Recommendation Report for Planning Permission for Works or Extension to a Dwelling

REF NO: EP/162/19/HH

LOCATION: 2 Meadow Park
East Preston
BN16 1EG

PROPOSAL: Single storey front and rear extensions and garage conversion.

Proposed Extension and Alterations
at 2 Meadow Park, East Preston
for Mr P Burrell
Drawing P01 December 2019 Scale 1:100 @ A3
Planning Drawing - Floor & Roof Plans and Elevations

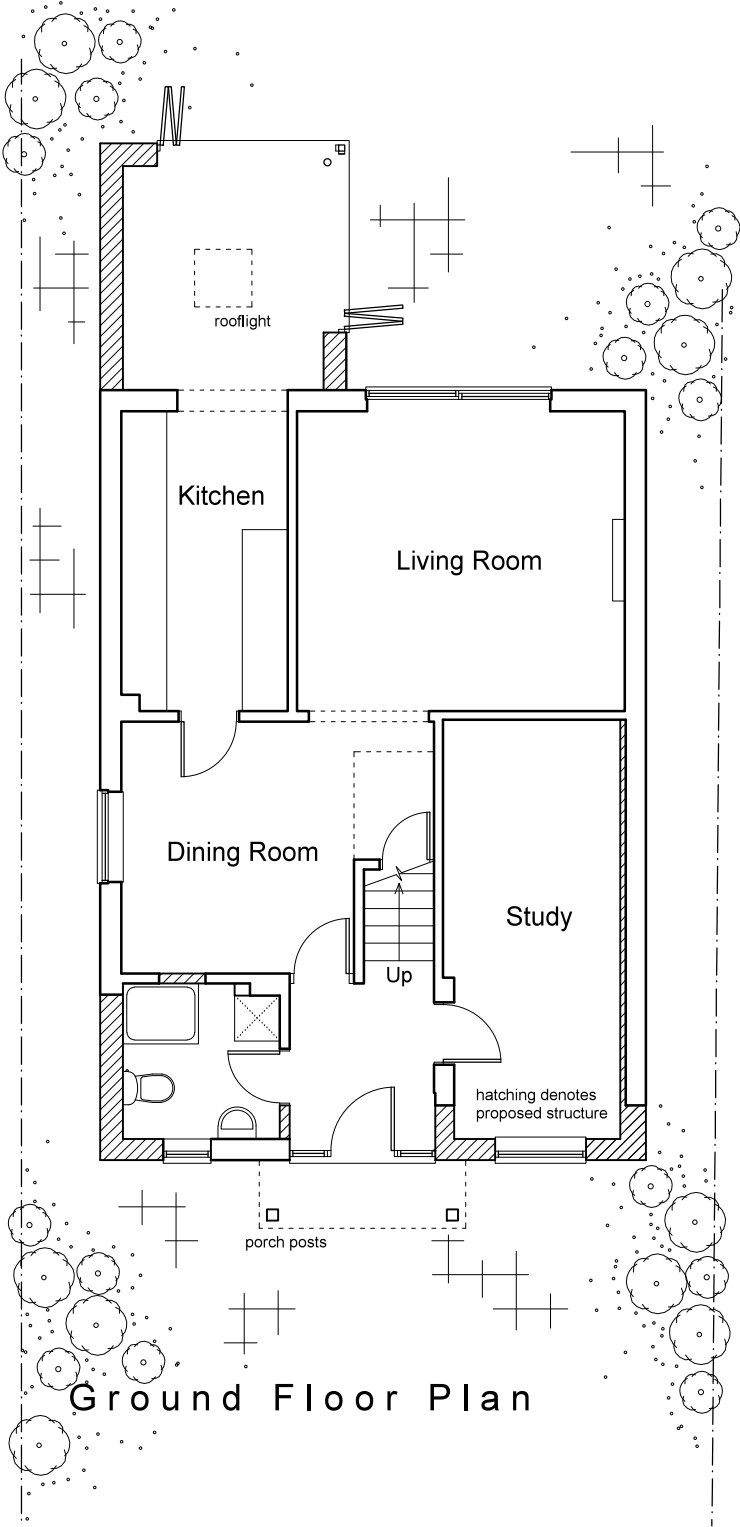
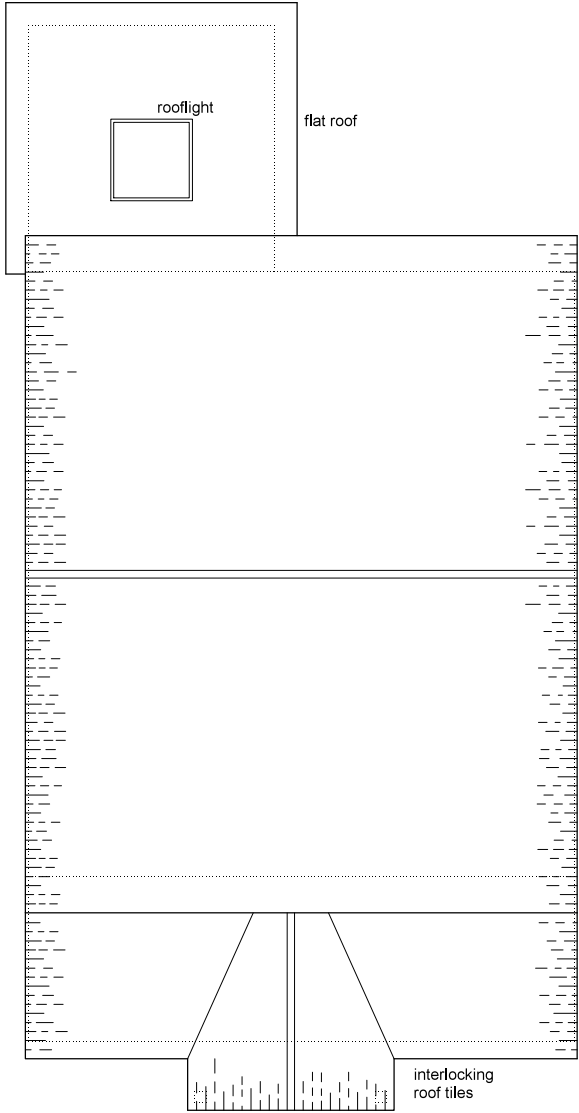
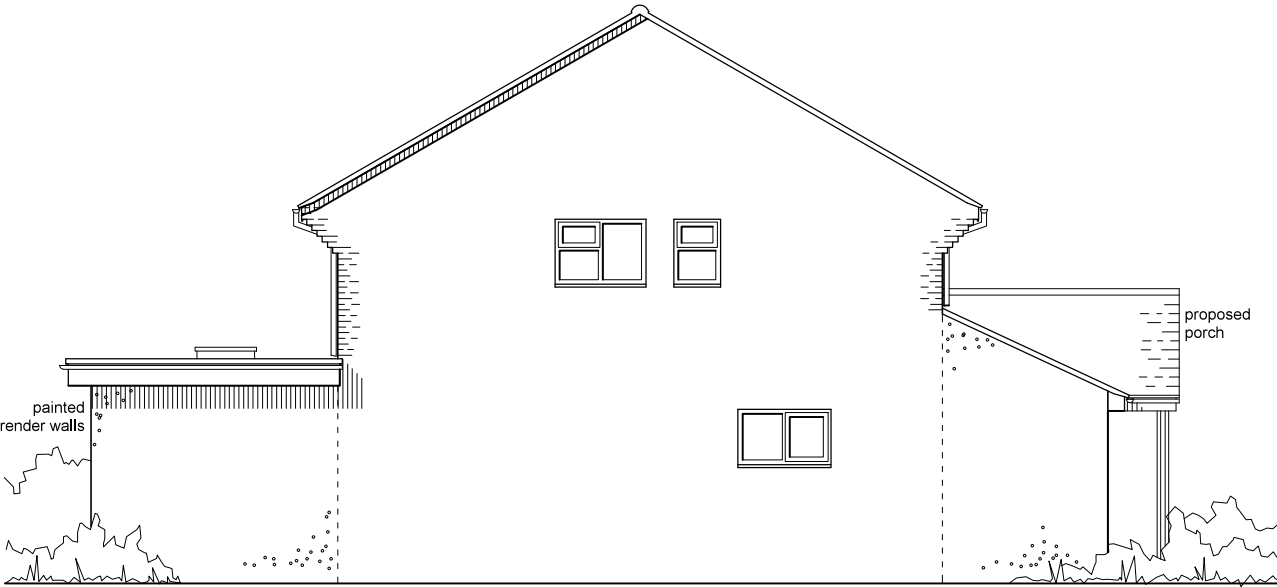
The proposed development is considered to result in a change in appearance to the host dwelling. However, this change is not necessarily considered to be harmful to the host dwelling. The front extension is considered to appear symmetrical, and sympathetic to the host dwelling.

The proposed rear extension is not considered to result in a significantly harmful impact upon the character of the host dwelling, or its locality. This is due to its siting at the rear of the host dwelling allowing for there to be no available views of the proposal from the public realm.

The proposed development is not considered to result in any significantly harmful impact upon the residential amenities of neighbouring dwellings, by way of overshadowing or overbearing impact. This is predominantly due to the modest scale of the proposed extensions, and their separation distance from neighbouring dwellings. With regard to loss of privacy, due to the single storey nature of the proposed extensions, they are not considered to provide any views that are currently unavailable from the host dwelling.
